Recommendation Report for Planning Permission for Works or Extension to a Dwelling

REF NO: BN/20/25/HH

LOCATION: 73 Elm Grove
Barnham
PO22 0HW

PROPOSAL: Single storey side extension.

FOR MR & MRS FRAZER		
SITE 73 ELM GROVE, BARNHAM WEST SUSSEX. PO22 0HW		
TITLE EXISTING & PROPOSED FLOOR PLANS		
SCALE 1:100 © A3	DRAWN AH 01/25	DRAWING NO. 02 REV

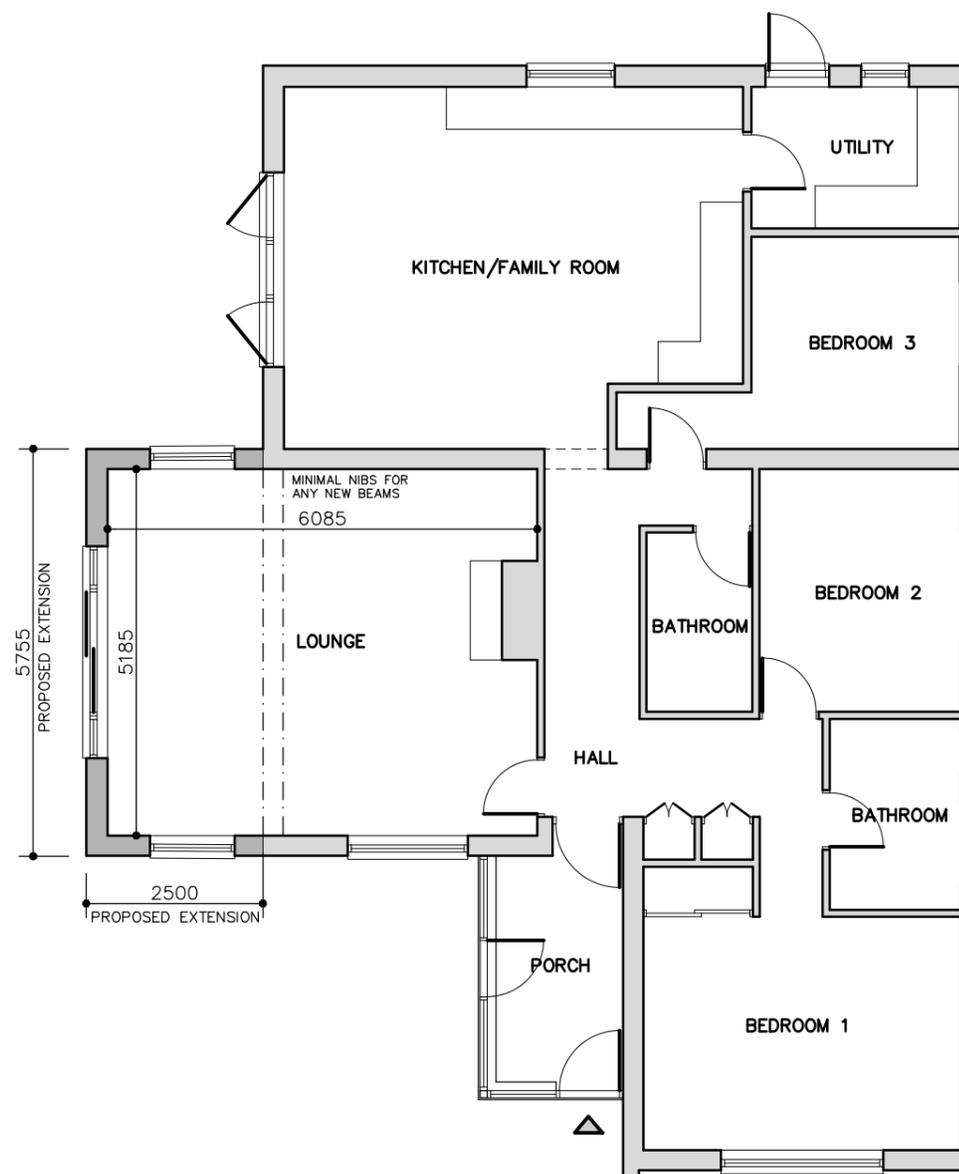
The proposal seeks a single storey gable roof side extension to the existing dwelling. This will project to the west of the property, and will retain 8.35m to the northern boundary, 8.842m to the west and 10.966m to the south. These distances are appropriately separated from any neighbouring properties, and as such the location and scale of the extension will not result in any overbearing or overshadowing.

FOR MR & MRS FRAZER		
SITE 73 ELM GROVE, BARNHAM WEST SUSSEX. PO22 0HW		
TITLE PROPOSED EXTENSION - ELEVATIONS		
SCALE 1:100 © A3	DRAWN AH 01/25	DRAWING NO. <b>04</b> REV

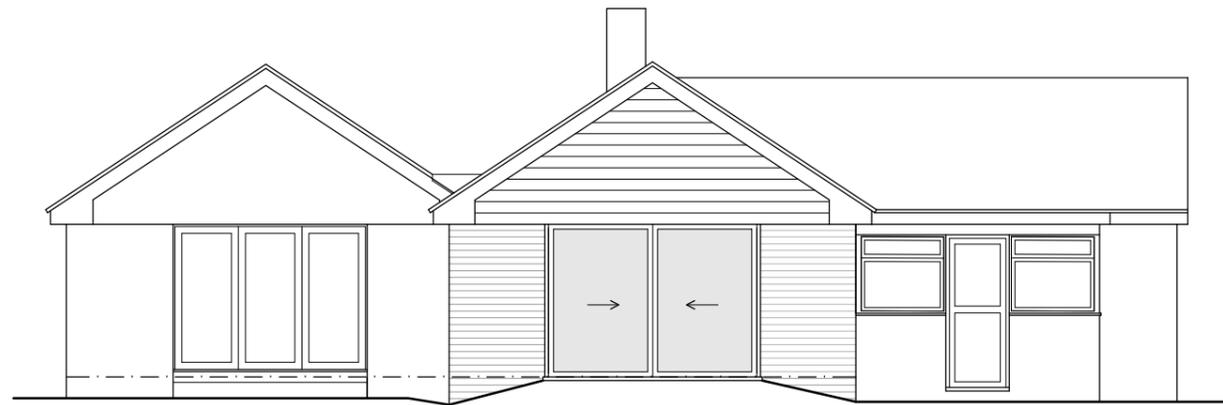
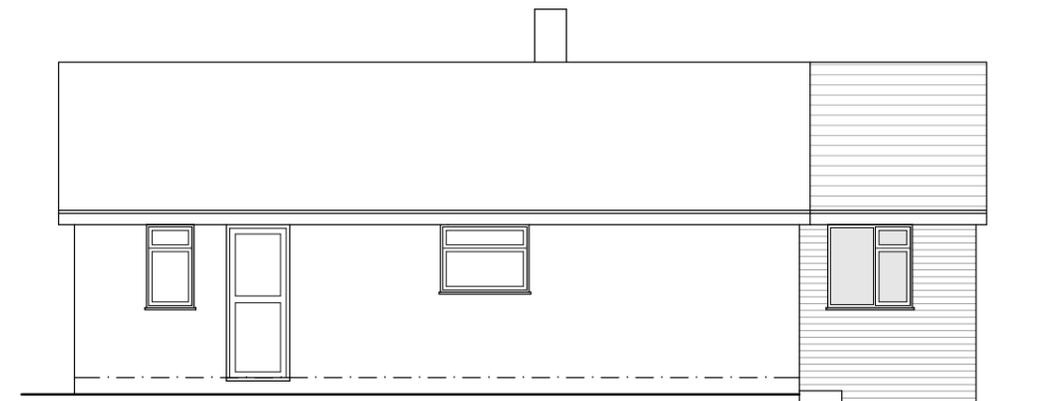
This extension will measure 2.5m deep and 5.755m wide, and project from an existing gable end. This gable end will be preserved, but projected 2.5m deeper than it is at present. Subsequently, the extension will retain the established roof design, ridge and eaves height, and will present as a subservient addition to the side of the property which integrates sympathetically with the host. As a result, it will have no adverse harm to the visual appearance of the property, and will remain in keeping with the established character.

No.73 is situated on a corner plot with Elm Grove and Orchard Way, and as such its western and southern elevations are visible from the public realm. Being to the west, the extension will be visible from the street scene, and have some impact on the composition and appearance of the area. However, the property at present is fairly obscured from visibility due to a mixture of hard and soft landscaping along the corner boundary. This comprises a 1.8m-2m high close boarded timber fence, and trees and shrubbery. As such, the extension will be of limited visibility, and will have a minor impact on the composition and appearance of the area. It will not appear as a dominant or obtrusive structure within the street scene, and will have no harm to the character of the locality.

The proposal will introduce one window to the northern boundary, which will face towards the front and

side of No.72. This will result in some visibility of the front elevation; however will be no more harmful than existing openings along the northern elevation of No.73 which abuts the side elevation of No.72. These are far closer and more intrusive than the proposed window. As such, the development will not result in any adverse harm to the privacy or amenity of nearby occupiers, and is acceptable.
